**Consultation Response from KC,
Highways Development Management**

2025/91959 Butchers Arms, Halifax Road, Staincliffe, Dewsbury, WF13 4AZ

Alterations to former public house and flat to form 8 flats

Date Responded: 03/09/2025

WF13 4AZ - BUTCHERS ARMS
LAYOUT PLANS
PROPOSALS

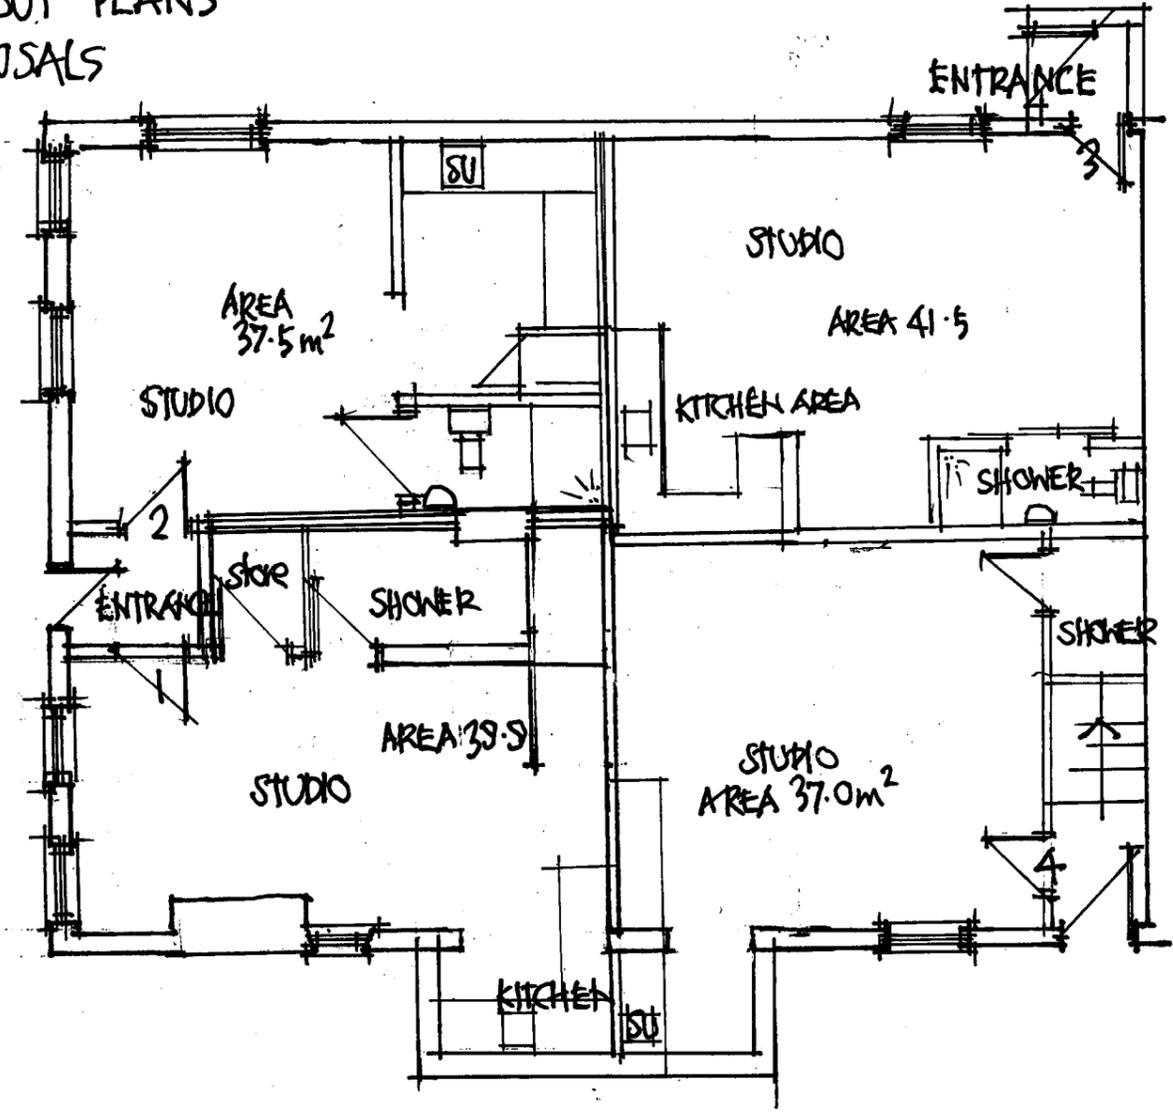
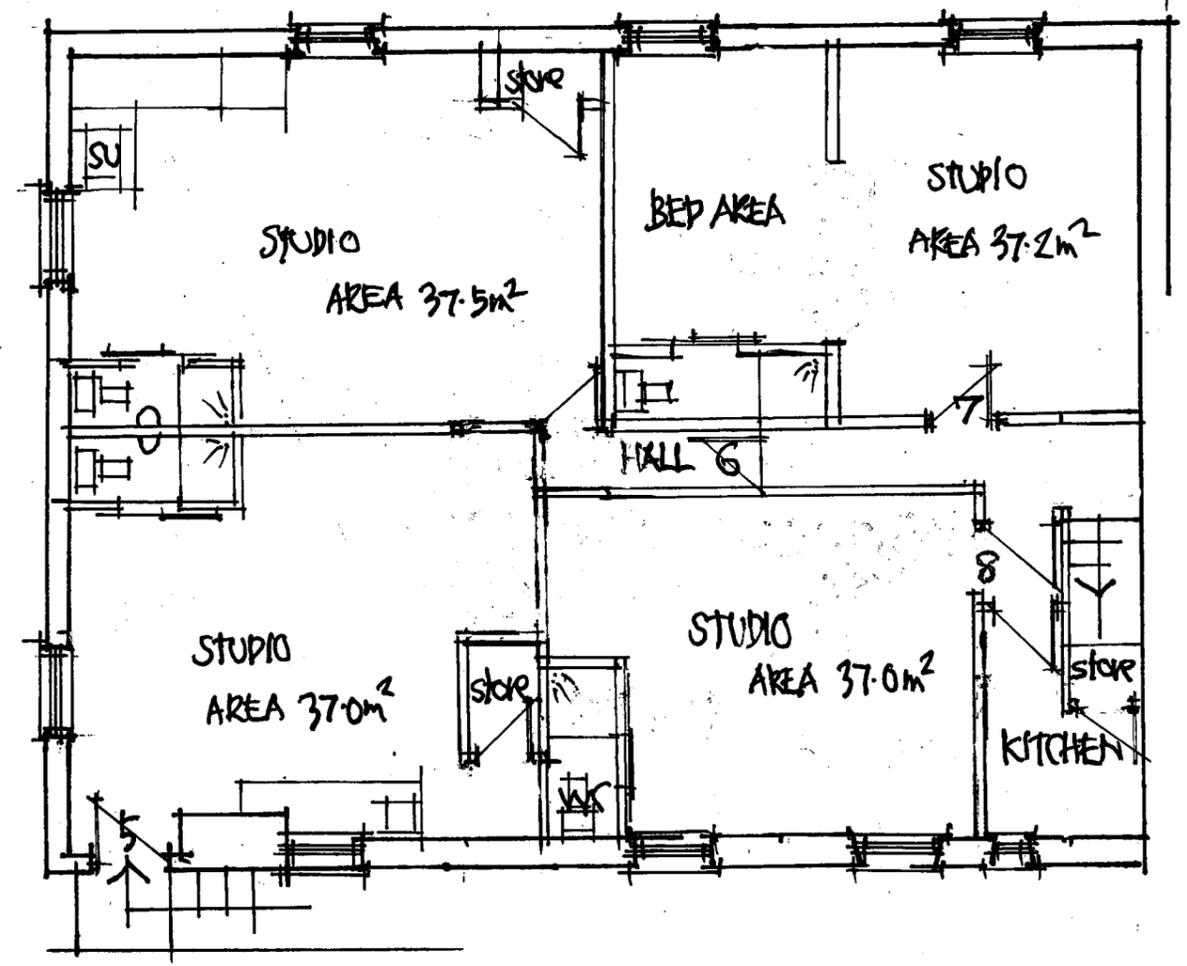
As an initial point of reference for residential developments (unless otherwise evidenced), it is considered that new:1-2-bedroom apartments should provide one car parking space per apartment. However, no off-street parking is available for the residents

One secure cycle space per unit is recommended. However, no cycle storage has been provided.

No bin storage areas are shown. A bin collection/presentation point should be located adjacent to the public highway. The bin collection/presentation point must not obstruct the adopted highway or the access road.

Details of waste storage and collection should be provided, with the location of a waste collection presentation point being clearly marked on a drawing in such a location that is easily accessible to the collection team and where it will not obstruct the parking, access or the adopted highway for road safety reasons.
